From: Laura Gibbons <Laura.Gibbons@arun.gov.uk>
Sent: 18 January 2022 11:23
To: Planning.Responses <Planning.Responses@arun.gov.uk>
Cc: David Easton <David.Easton@arun.gov.uk>
Subject: RE: Planning Consultation on: Y/127/21/RES

Engineers Comments Regarding Surface Water Drainage

Application No:	Y/127/21/RES
Registered:	10th September 2021
Site Address:	Land at Bilsham Road Yapton
Grid Reference:	497588 102751
Category:	Plan Applicat'n
Description of Works:	Approval of reserved matters (appearance, landscaping, layout and scale) following the grant of Y/91/17/OUT for 250 No dwellings with associated parking, road/footway/cycleway provision, open space, landscaping, surface water attenuation & ancillary works (resubmission following Y/152/20/RES). this site is not CIL Liable as in Yapton Strategic Site.

drawing title
Landscape Proposals - Sheet 2

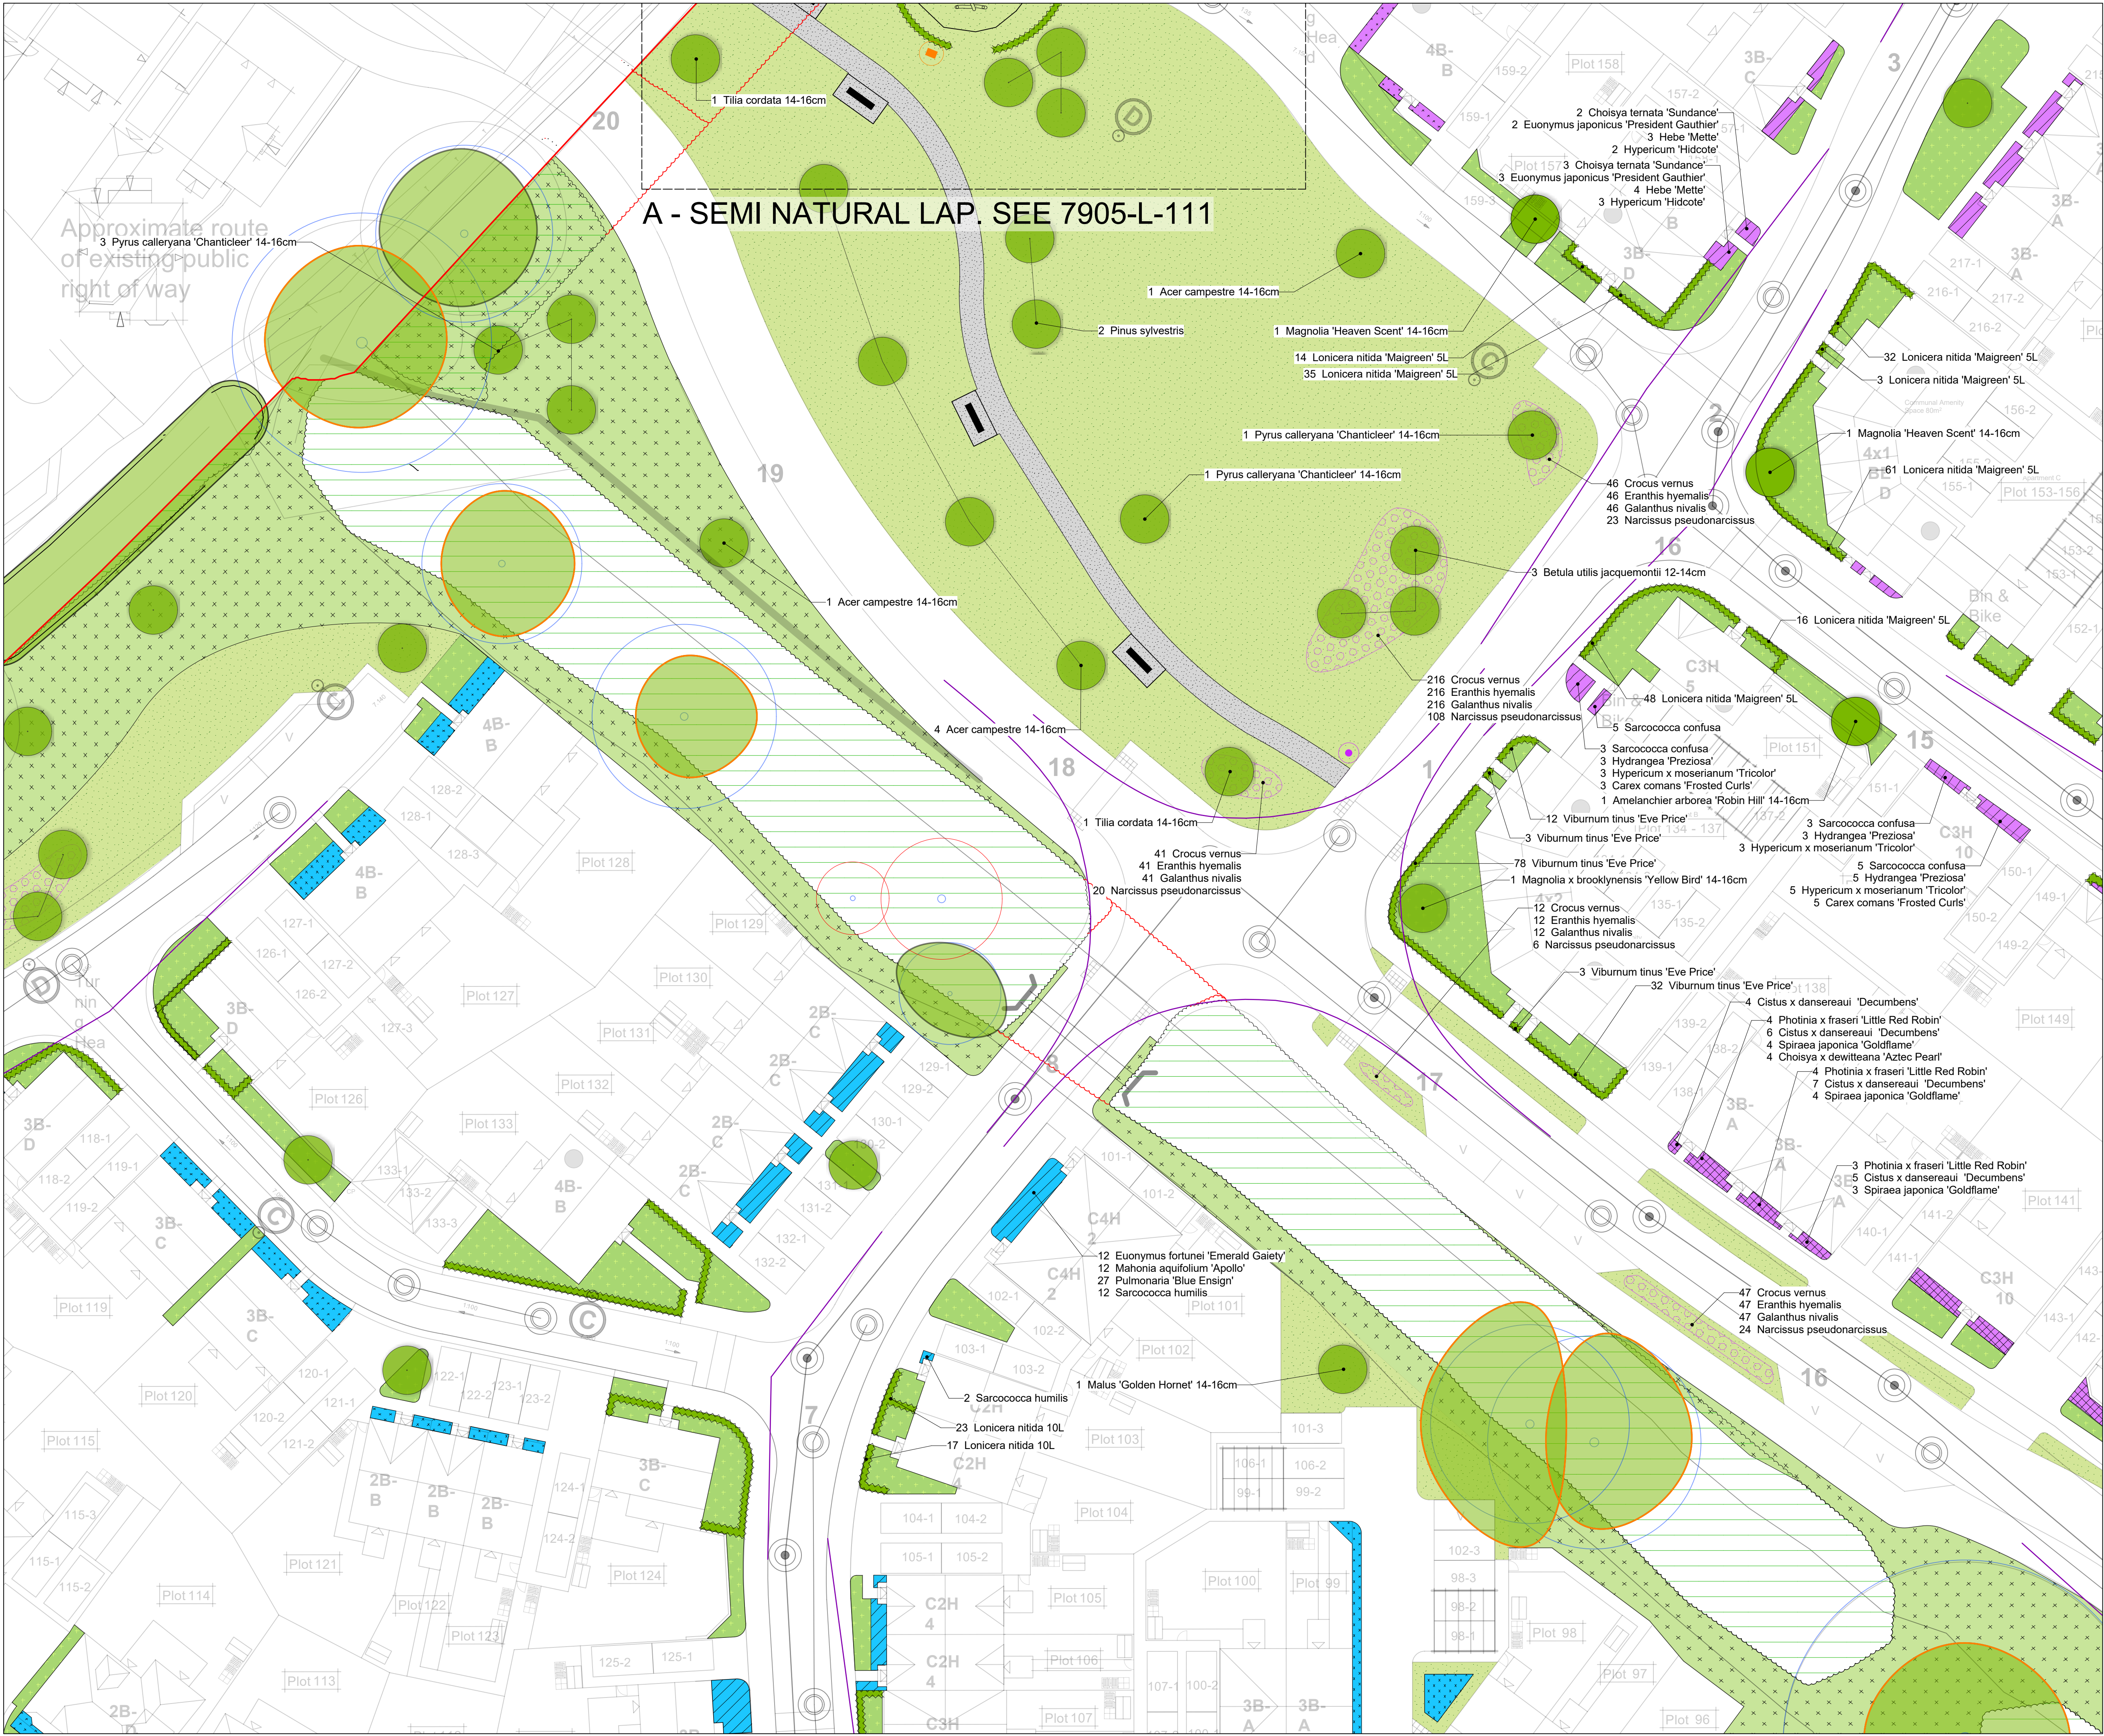
A 3m buffer plan has now been provided which shows that 3m clear access is being provided around watercourses and basins. We still have concerns regarding landscaping proposals. It has not clearly been evidenced that tree root potential areas will not conflict with surface water drainage features.
